From: Simon Davis
Sent: 30 November 2018 10:58
To: Planning.Responses
Subject: FW: WSCC Planning Consultations on AL/116/18/PL and AL/117/18/PL

From: Katie Kurek [REDACTED]
Sent: 28 November 2018 16:36
To: Simon Davis
Subject: RE: WSCC Planning Consultations on AL/116/18/PL and AL/117/18/PL

I attach revised plan received from Scandia Hus produced in line with the WSCC requirements. Please note that this new revised plan is labelled as SP01 Rev C which needs to replace the reference in the applications to plan SP01 Rev B.

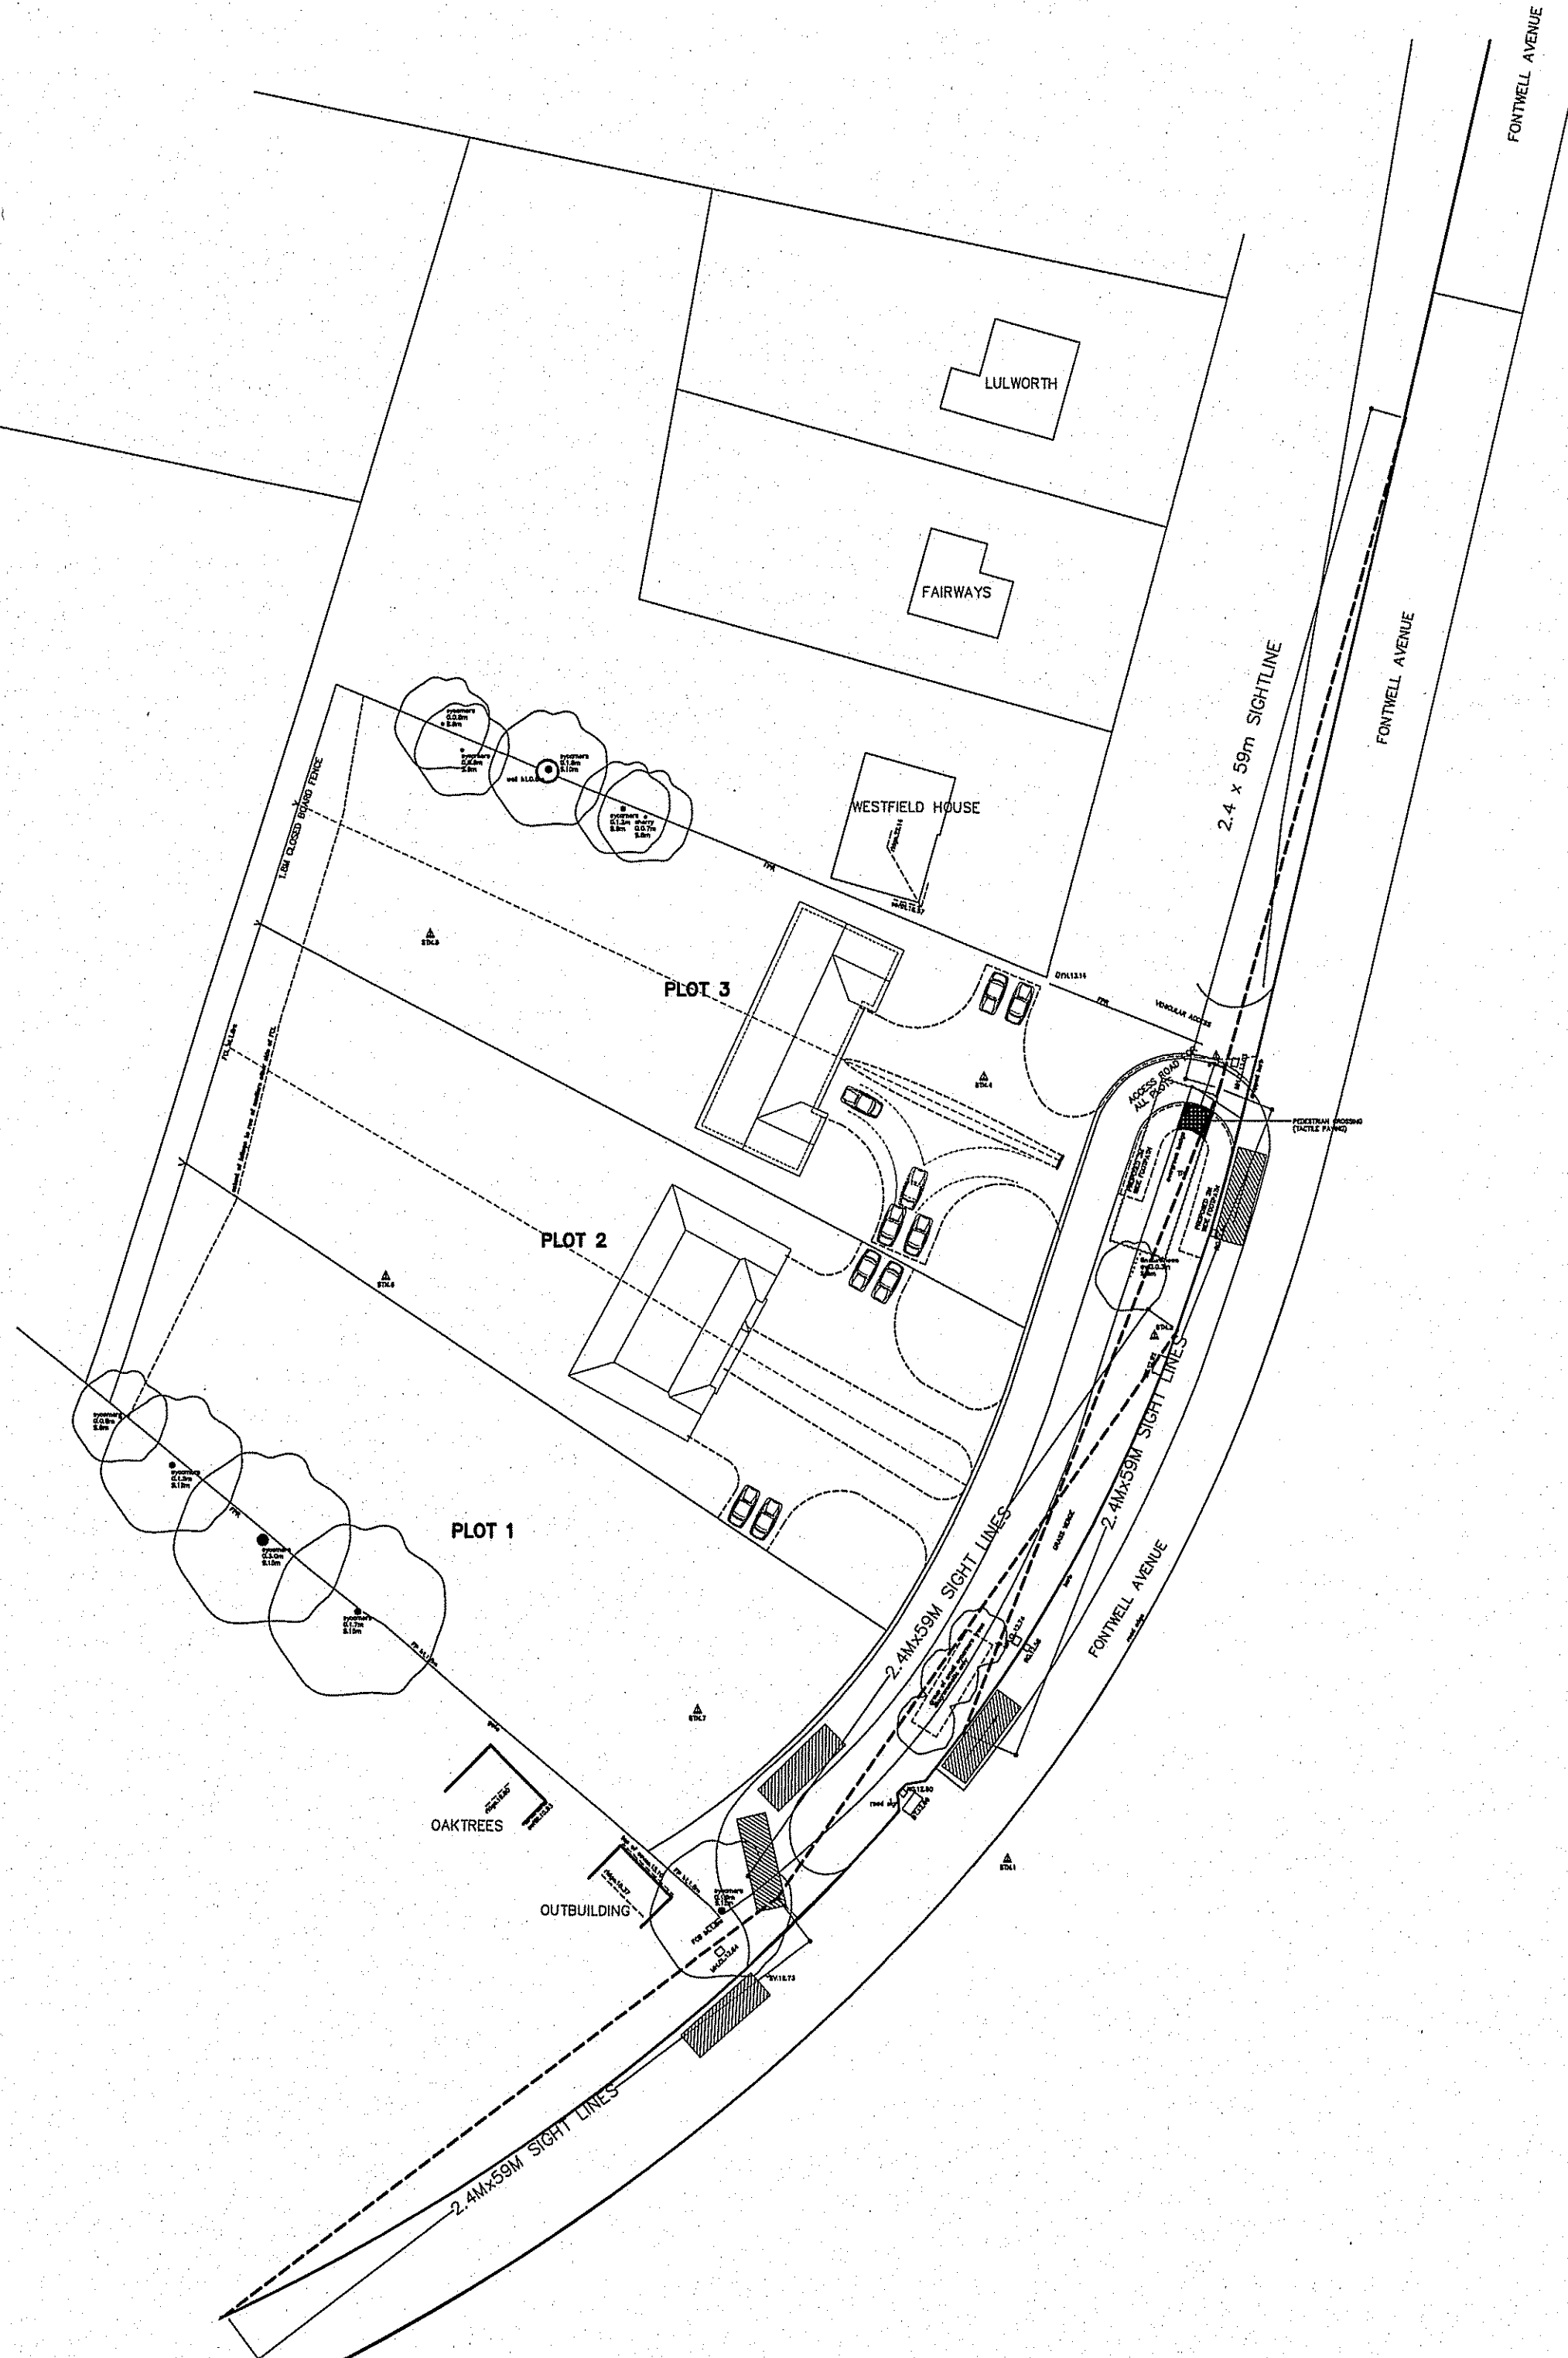
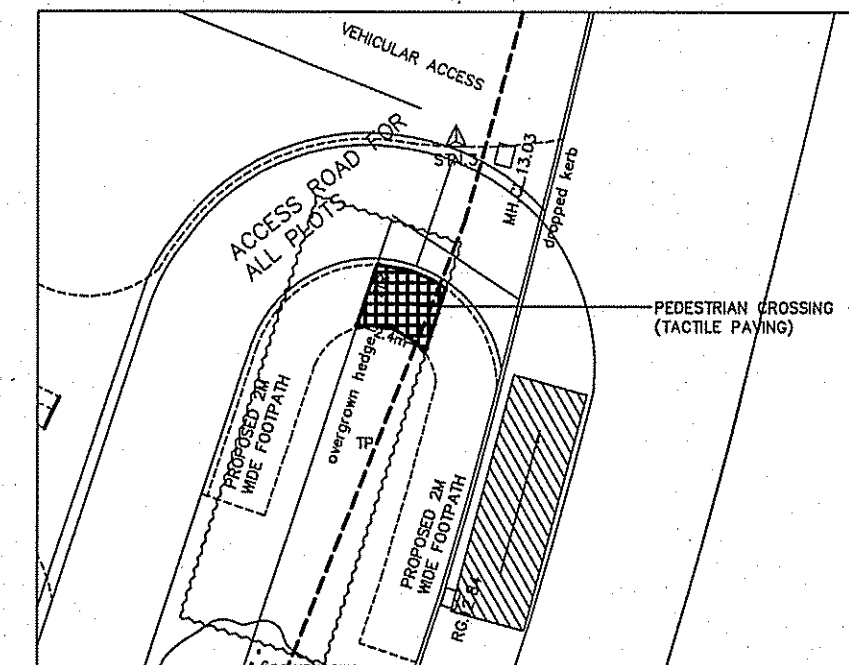
I appreciate the correct splays have now been indicated but ideally the red edge of the site should also be included so we can ensure that these pass through applicant maintained land and public highway only. I also note they have only indicated one of the pedestrian crossings on one side of the road whereas the approved site plan under AL/136/17 shows all four ped crossing points and proposed footway in greater detail. For consistency sake, this should be provided. The RGP drawings approved under AL/136/17 show this in clearer detail.
